Bioregional's response to application 21/04275/OUT – Part OS Parcel 8149 Adj Lords Lane And SE Of Hawkwell Farm Lords Lane Bicester

Application description: OUTLINE - with all matters reserved except for Access - Mixed Use Development of up to 3,100 dwellings (including extra care); residential and care accommodation(C2); mixed use local centre (comprising commercial, business and service uses, residential uses, C2 uses, local community uses (F2(a) and F2(b)), hot food takeaways, public house, wine bar); employment area (B2, B8, E(g)); learning and non-residential institutions (Class F1) including primary school (plus land to allow extension of existing Gagle Brook primary school); green Infrastructure including formal (including playing fields) and informal open space, allotments, landscape, biodiversity and amenity space; burial ground; play space (including Neaps/Leaps/MUGA); changing facilities; ground mounted photovoltaic arrays; sustainable drainage systems; movement network comprising new highway, cycle and pedestrian routes and access from highway network; car parking; infrastructure (including utilities); engineering works (including ground modelling); demolition

ILLUSTRATIVE FRAMEWORK MASTERPLAN

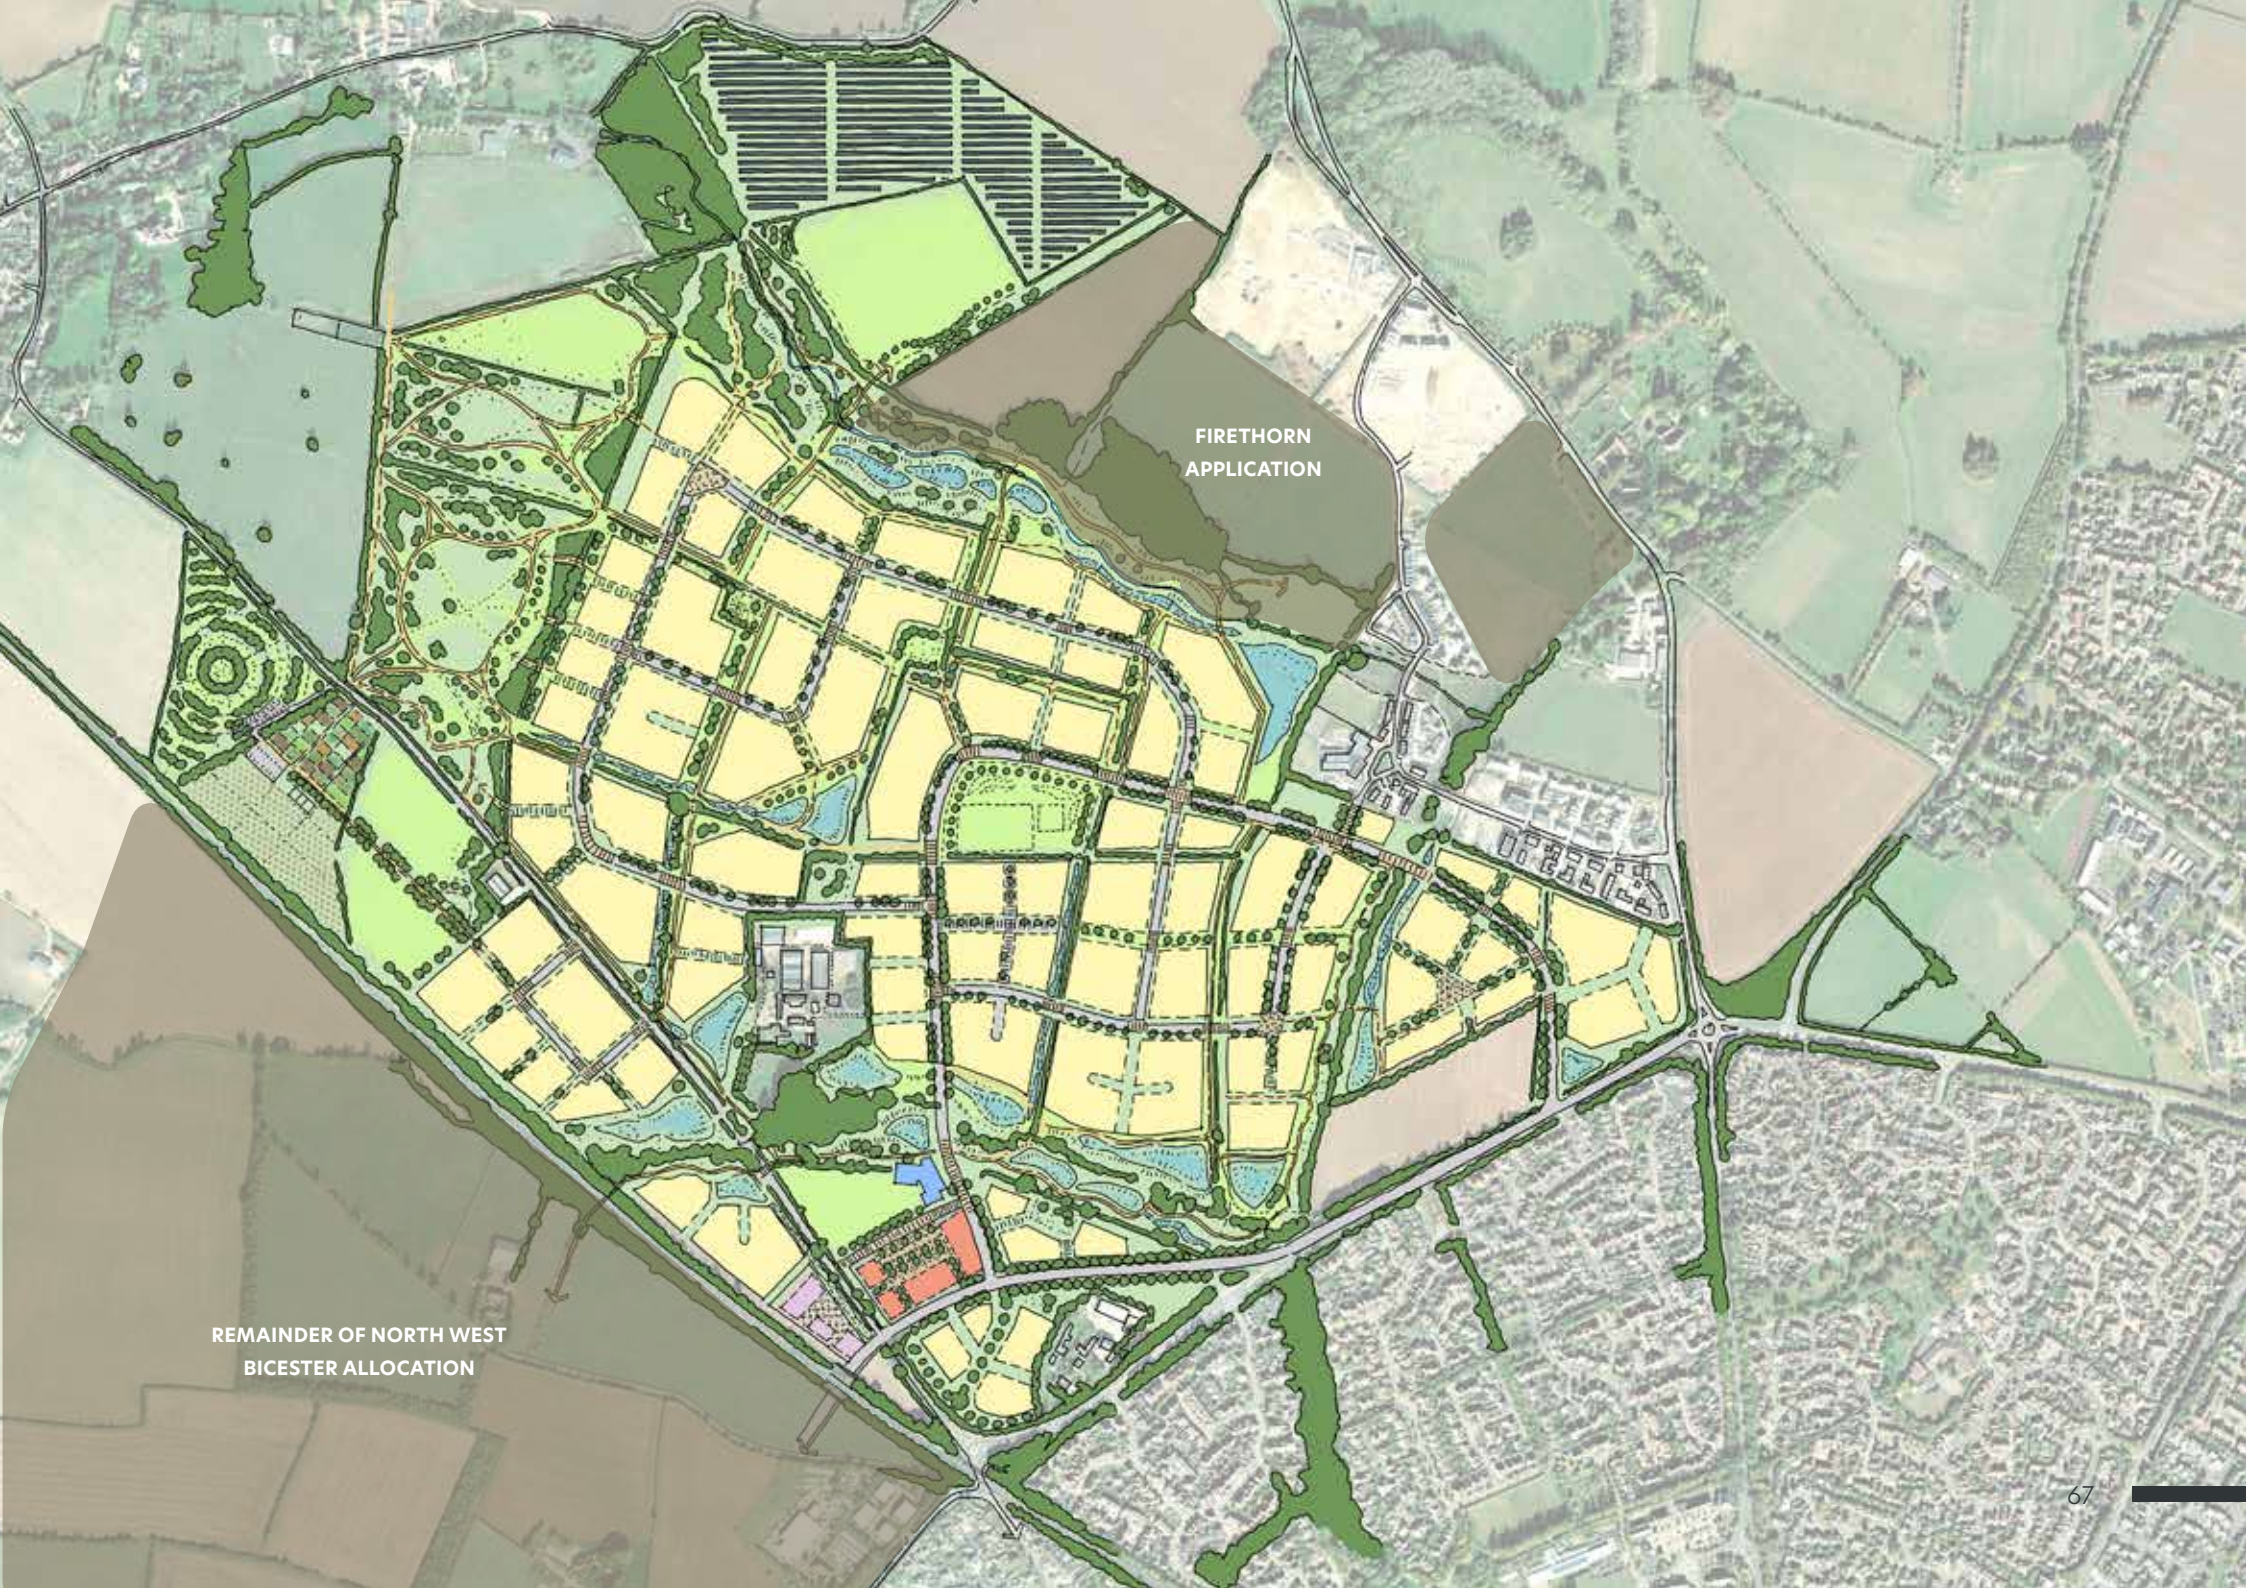
<p>A well designed approach to the urban edge, which relates development at the periphery to its rural setting and affords good access to the countryside, minimising the impact of development when viewed from the surrounding countryside</p>	<p>The Development Framework Plan shows that the primary infrastructure, employment/business space and primary school are located in the south corner, nearest to Bicester. The Green infrastructure and PV array are proposed for the furthest areas of the site from Bicester.</p>	<p>Development Framework Plan, David Lock Associates, November 2021</p>	<p>Full compliance with this policy requirement is to be assessed by others.</p> <p>However we do note that this propose development extends beyond the existing red line for NW Bicester location. This would push the development close to the boundary of the village of Bucknell. Which could have a significant impact on the impact of the village,</p>

<p>both visually but also on the rural identity of the parish.</p> <p>Whilst the application does refer to GI and the PV arrays to the northern edges, closest to Bucknell significantly more investigation is required to understand the mitigation of any proposed extension beyond the 2014 masterplan.</p>
<p>Development that respects the landscape setting and that demonstrates enhancement, restoration or creation of wildlife corridors to achieve a net gain in biodiversity</p>	<p>Insufficient information provided.</p>	<p>Hawkswell Village Design and Access Statement, David Lock Associates, December 2021</p>	<p>There are mentions of biodiversity net gain within the application documents, but we could not find the DEFRA metric that would calculate the minimum 10% net gain on site. The requirement to meet net gain is mentioned in the ES but no reference to the achievement is found.</p> <p>We would suggest that a Biodiversity Strategy is submitted, and the net gain achievement is demonstrated prior to commencement.</p> <p>In addition no reference is made on the off-site mitigation for farmland bird loss. This is part of the NWB SPD whereby off-site mitigation measures should be provided.</p>
